WELWYN HATFIELD COUNCIL  
PLANNING CONTROL COMMITTEE – 28 AUGUST 2008  
REPORT OF THE CHIEF PLANNING AND ENVIRONMENTAL HEALTH OFFICER

S6/2007/0925/MA

RESIDENTIAL DEVELOPMENT OF 40 UNITS; COMPRISING OF FLATS, DWELLING  
HOUSES AND HIGHER NEEDS SUPPORT UNIT, INCLUDING ACCESS AND  
LANDSCAPING, FOLLOWING DEMOLITION OF EXISTING BUILDINGS

HAZEL GROVE PRIMARY SCHOOL, HAZEL GROVE, HATFIELD, AL10 9DX

Front Elevation

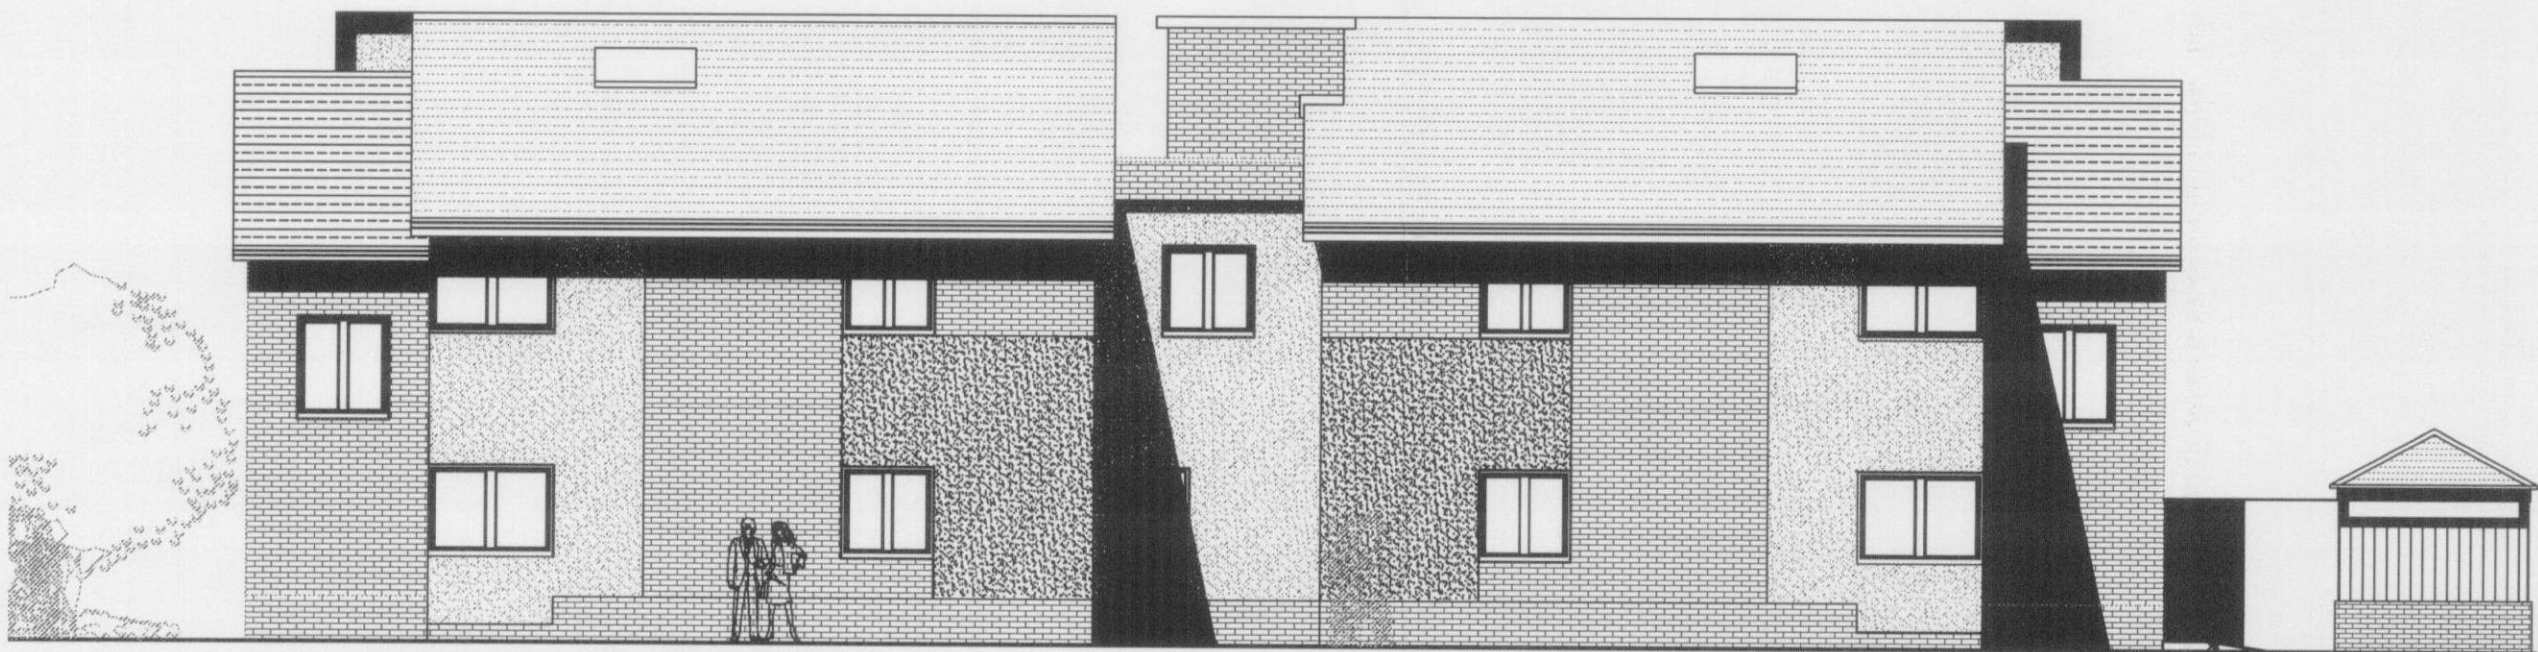
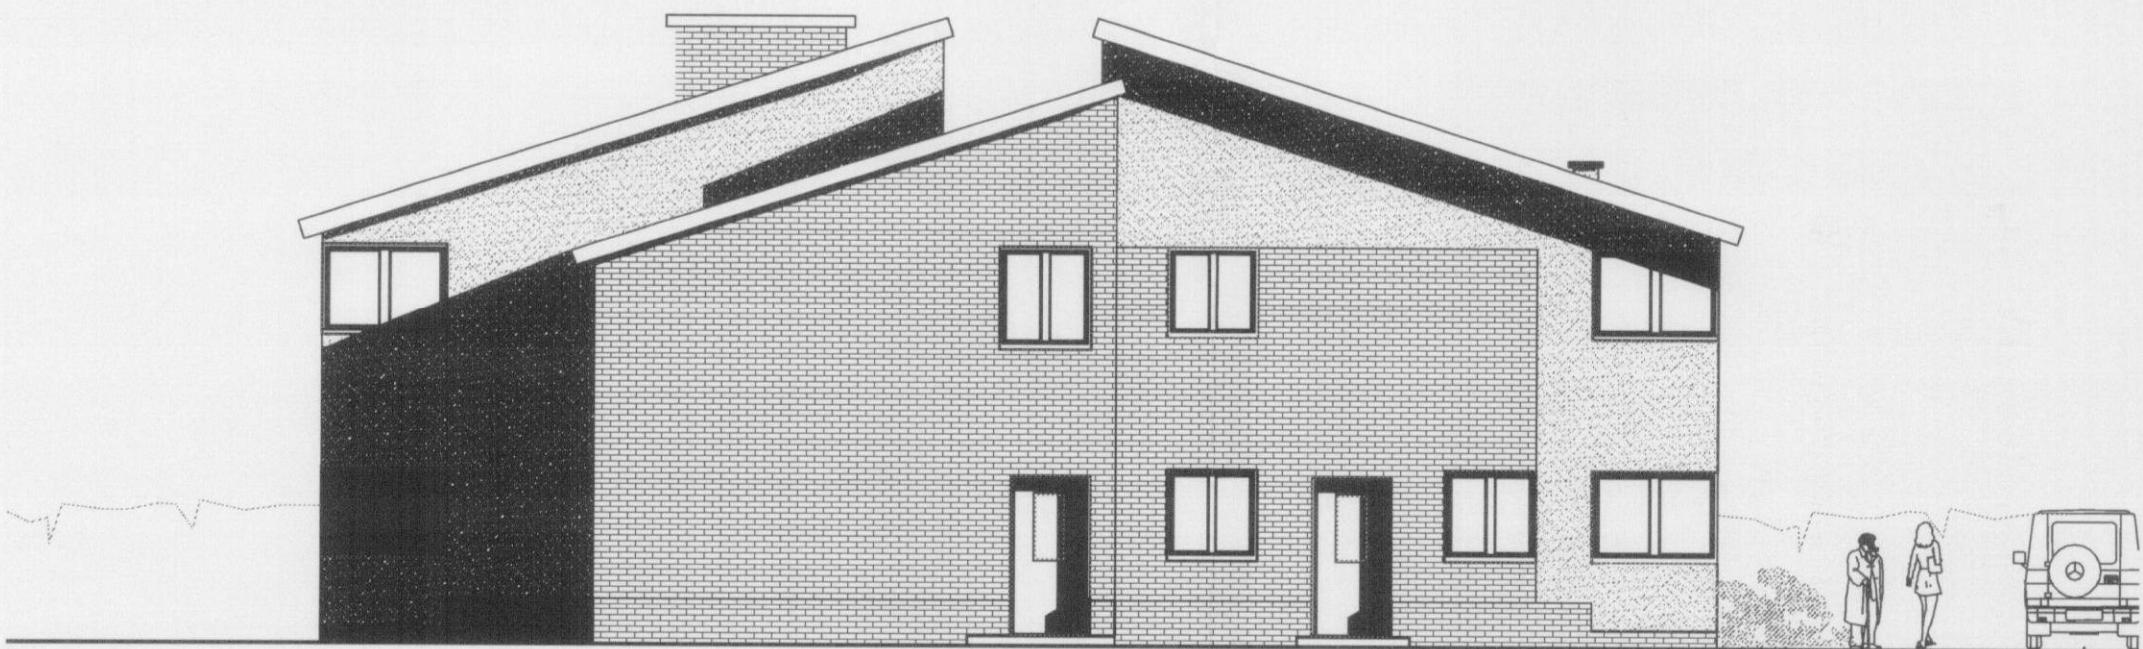
- 2.5 **Block B:** flank obscured window to plots 10 and 14 to the bathrooms.
- 2.6 This will allow natural ventilation and daylight to the units whilst preventing any loss of amenity to adjoining units. An additional condition is recommended to the previous report presented to Members for obscured glazing to these and other relevant windows, as discussed below.

Job No. 5678	Drawing No. PL112	Revision P2
-----------------	----------------------	----------------

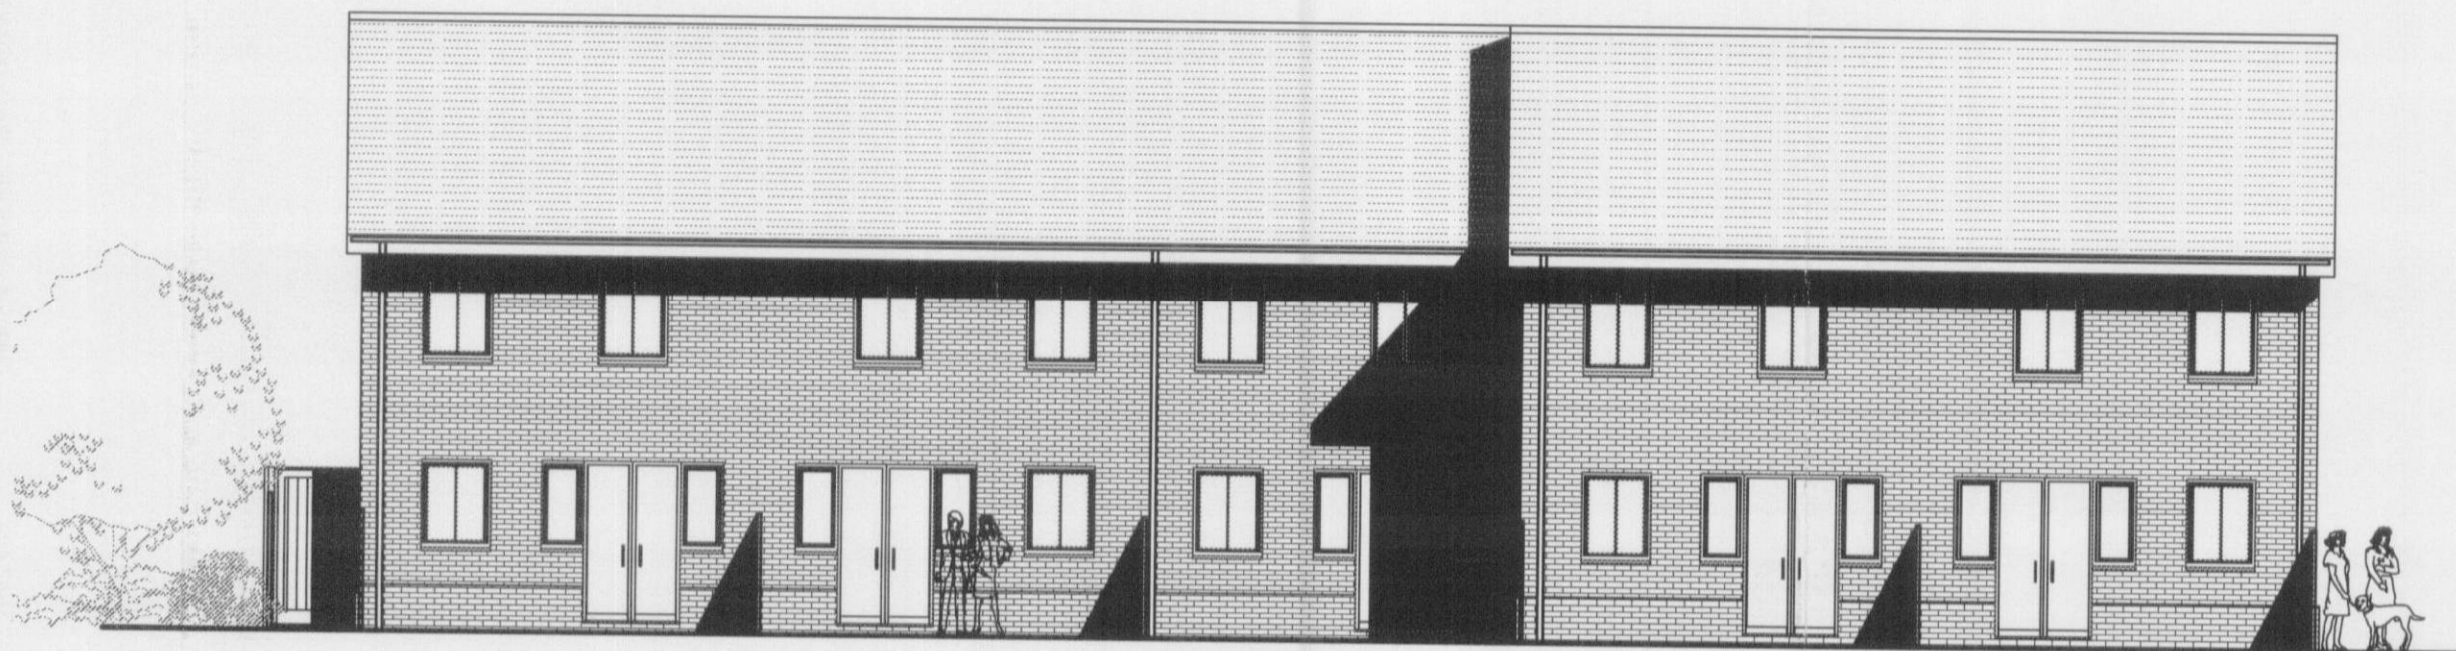
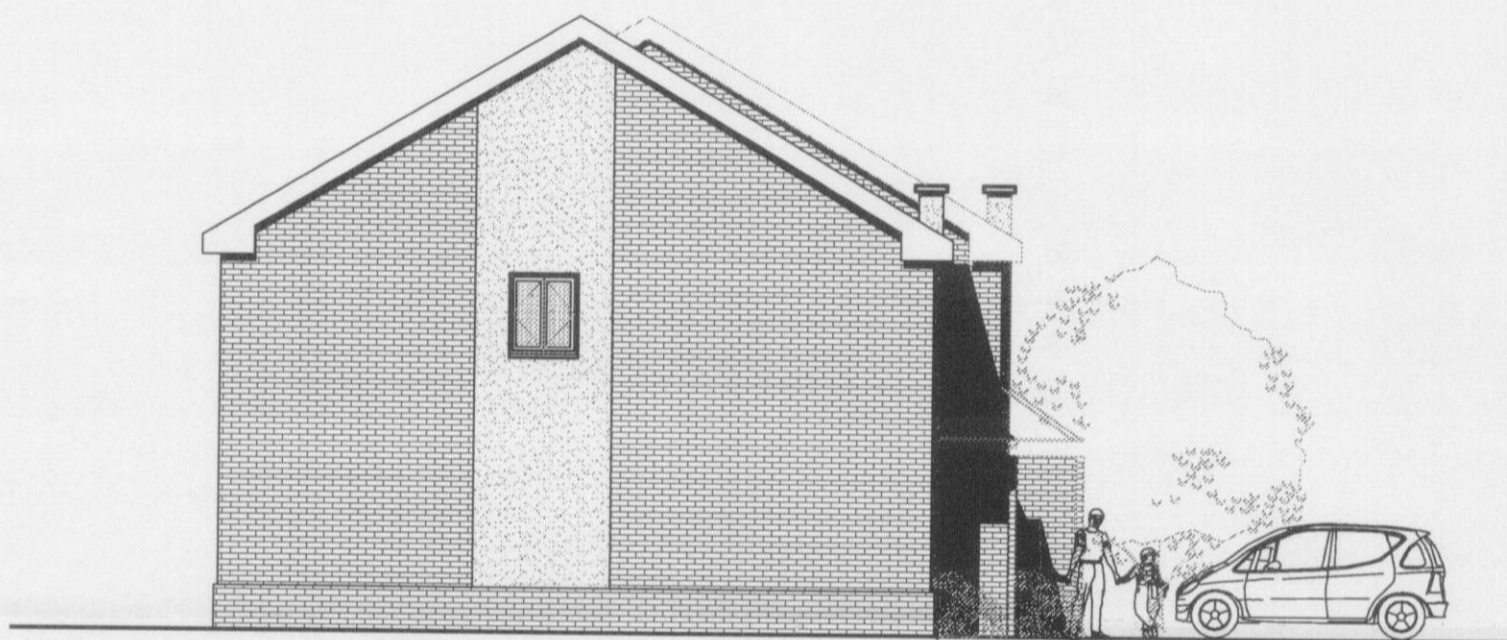
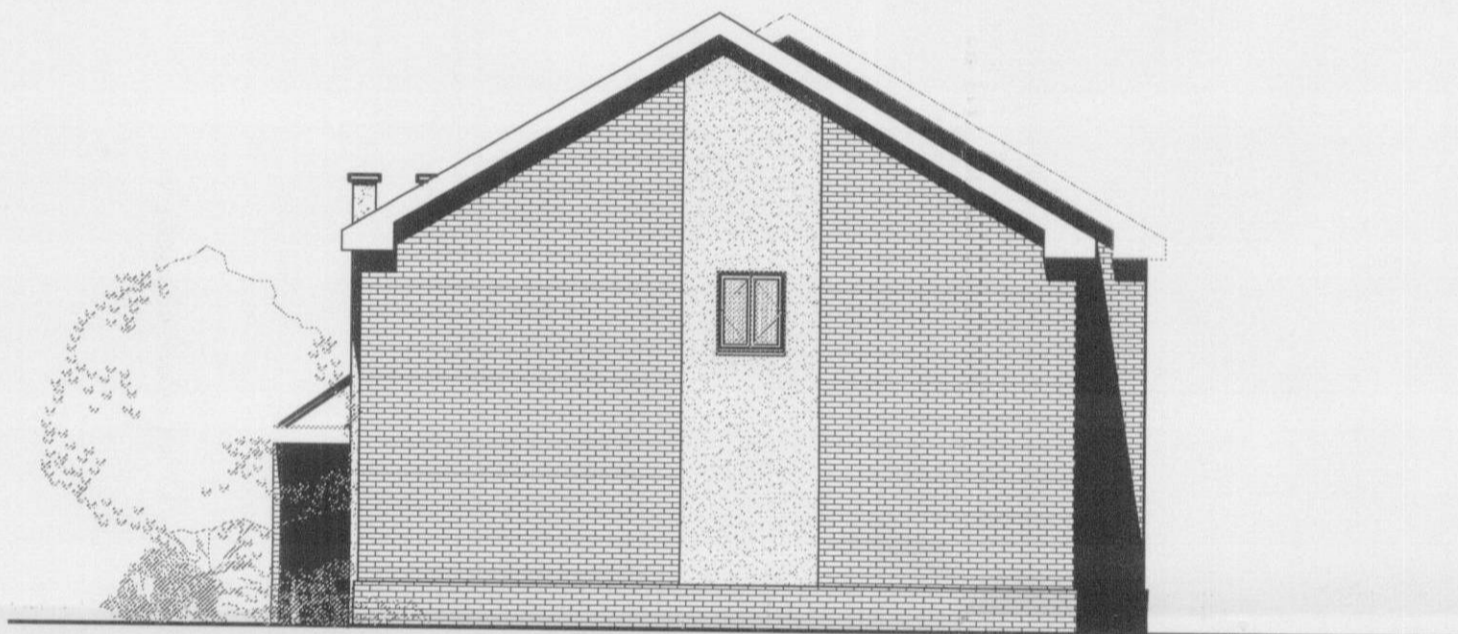
- 2.7 **Block C:** flank obscured first floor windows to the bathrooms to plots 1, 5, 6 and 9. The same considerations apply as the previous paragraph.

Job No. 5678	Drawing No. PL113	Revision P2
-----------------	----------------------	----------------

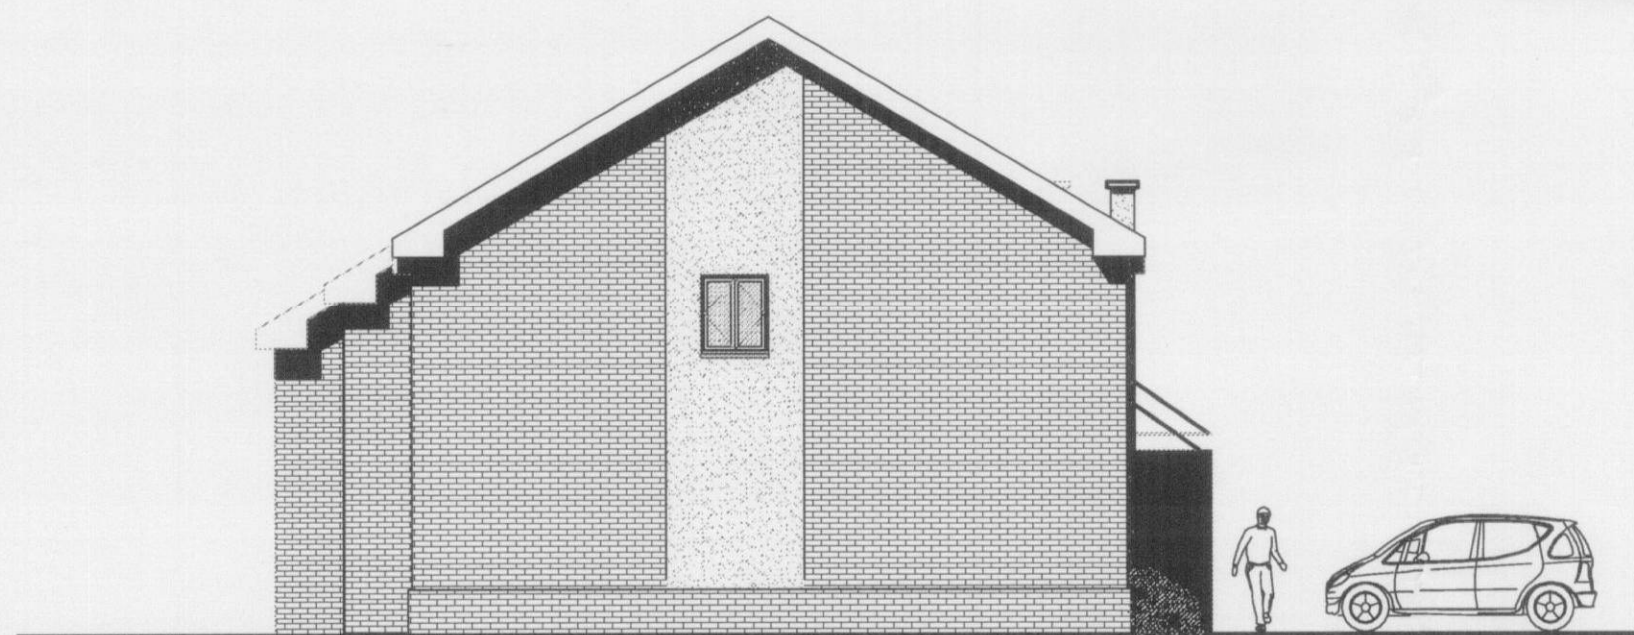
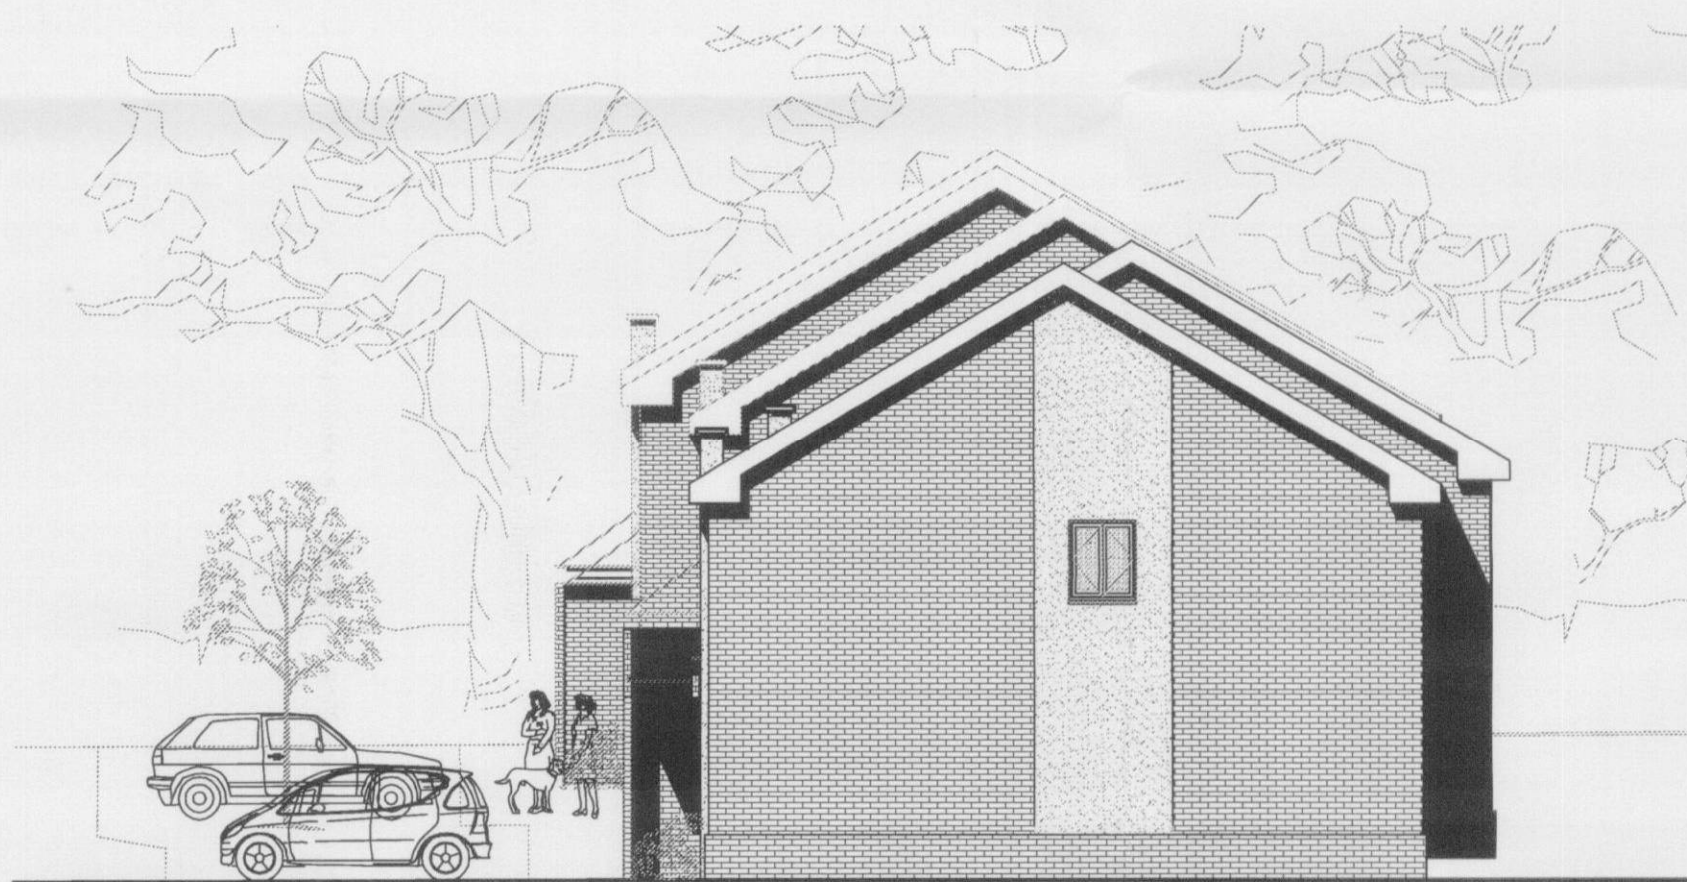
- 2.10 **Block E:** flank obscured window to plot 15, solar panels to the rear elevation of plots 15-18. Additionally, it is proposed to widen plot 18 by 300 mm in order to

comply with Lifetime Homes Standards (to provide a wheelchair accessible WC at ground floor level).
